Town of Addison

Summary of Engineering Review Comments

Date: August 23, 2019
 Plan Review : Civil Review 1
 Received: July 30, 2019
 Plan Date: July 25, 2019
 Development: Galaxy FBO

Town Project #:19-09D

**WATERLINE PLAN**

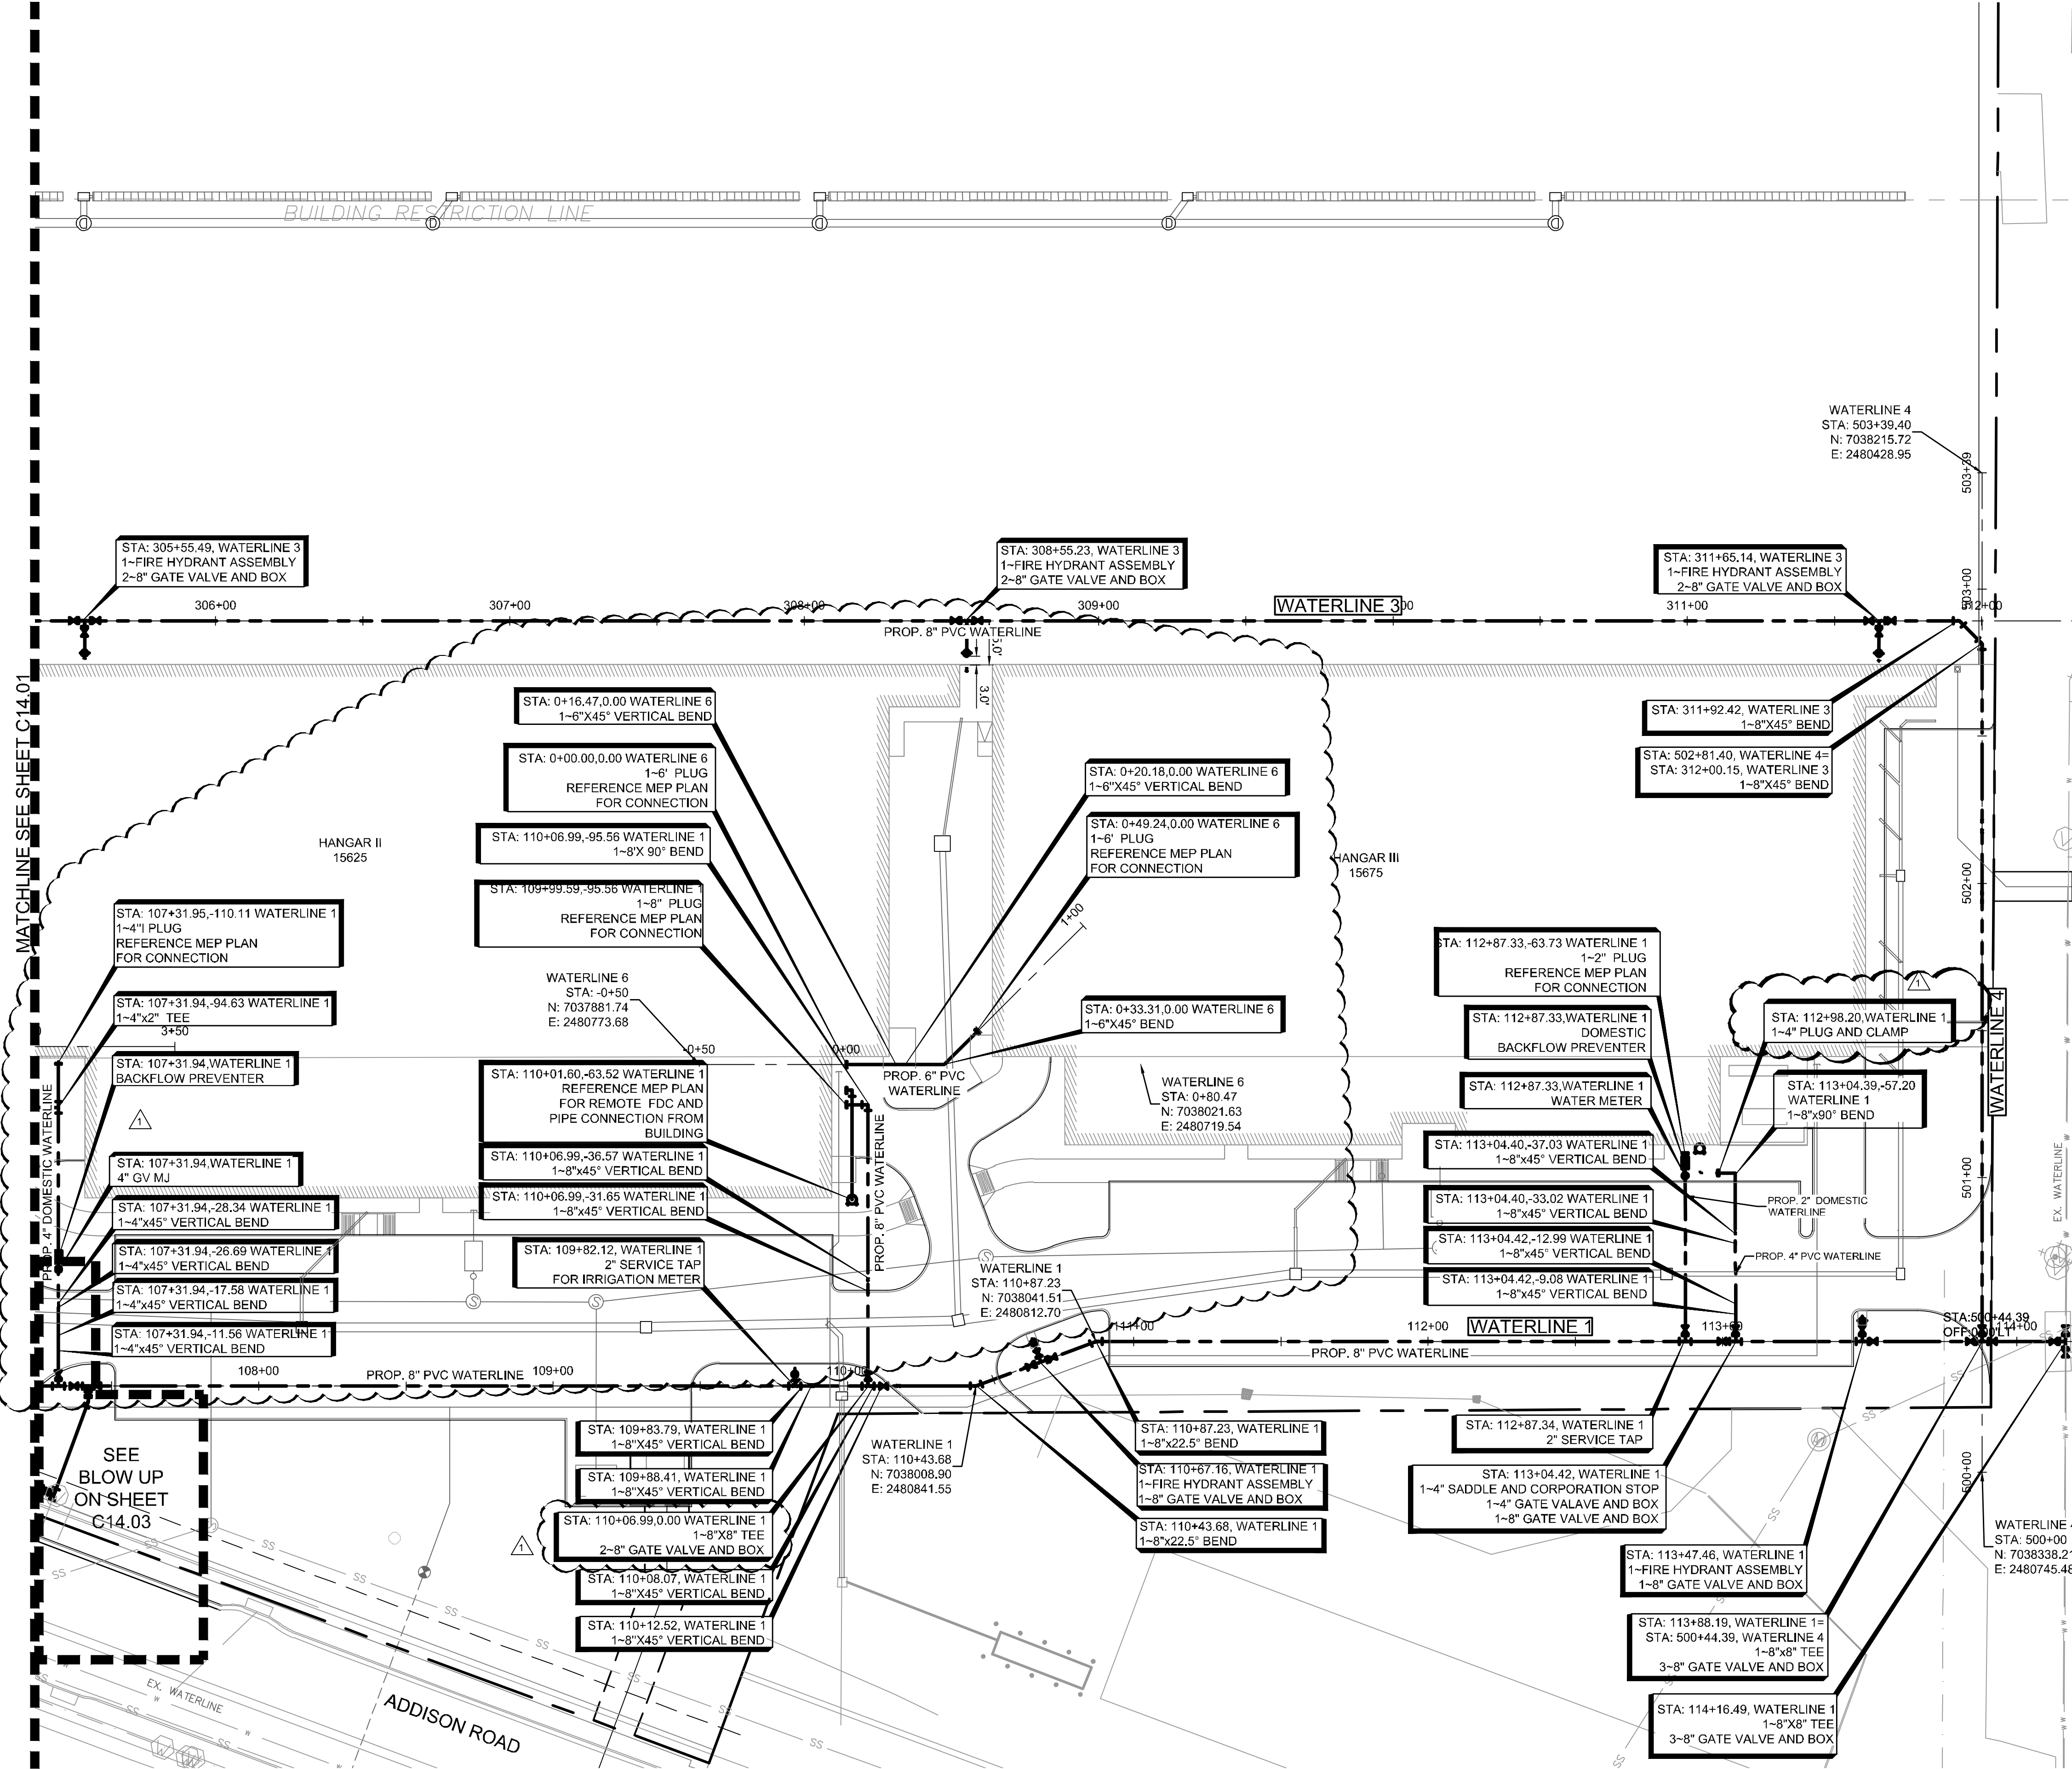
C14.01	Would like to see FHA @ 300+58 moved west & a tee added to get the distance.	DISAGREE	SEE THE CURRENT FIRE HYDRANT ASSEMBLY LOCATION ON SHEET C14.01.
C14.01	Why is a 4" plug on a 2" service at 102+83?	AGREE	
C14.01 & 14.02	Existing Addison Rd crossing should be connected to the proposed 8" water line. See markups for further info on connection & demo.	AGREE	THE FIRE HYDRANT HAS BE RELOCATED AND A CONNECTION HAS BEEN ADDED

Page No.	Comments	Response (See Note)	Explanation
C14.02	Check with Fire Marshall re: length of FDC from the hydrant at fire line STA 107+29 (if the circle @ end of line is an FDC).	AGREE	
C14.02	No water fittings within 10' of sanitary crossings.	AGREE	
C14.02	Ensure min. 10' separation (CL-CL) between water & sewer lines.	AGREE	
C14.03	On shallow clearances between SD & water w/ SD on top of water would like to see some kind of encasement (conc or steel) for those sections to protect against the weight and any future settling of the SD and SD embedment.	AGREE	SEE NOTE 5 ON WATERLINE PLAN SHEETS
C14.03	Show all crossings, including service crossings, in the profiles.	AGREE	
C14.03	Show valves in profiles.	AGREE	
C14.05	Not using RCCP water main - don't include RCCP embedment detail - use PVC detail SD-W01.	AGREE	
C15.00	Dimension the separation from the water & gas (min. 4')	AGREE	
C15.00	Include profile for Addison Rd crossing.	DISAGREE	THE GAS CROSSING THE ROAD WILL BE DONE BY GAS PROVIDER
